Application No: R/59/21/HH
Site Address: 9 Amberley Road Rustington BN16 2EF
Description of works: Extension of existing main roof over existing ground floor. Conversion of loft Space to create Master Bedroom. Construction of dormer to north roof slope.

Thank you for your internet representation made on 5th May 2021 which has been recorded as no objection with the comments as follows:

Side Elevation (north)

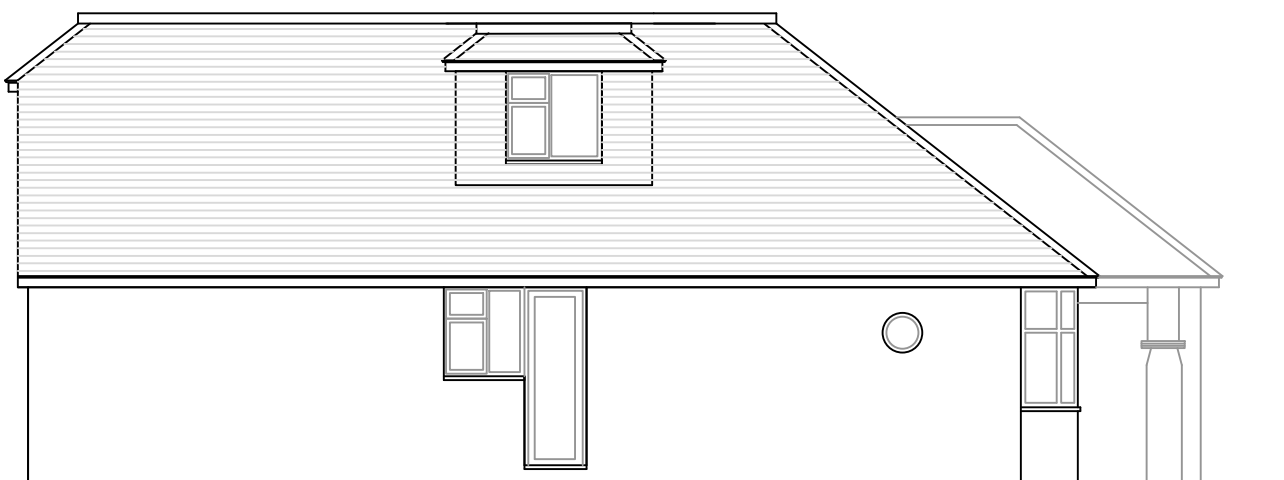
However, the Dormer to the North will overlook the whole of our property including our bedroom windows, lounge, conservatory, gardens and patio area. Additional screening would not be affordable or desirable here.

We therefore have no objection provided that the dormer window on the North side be made opaque and no-opening.
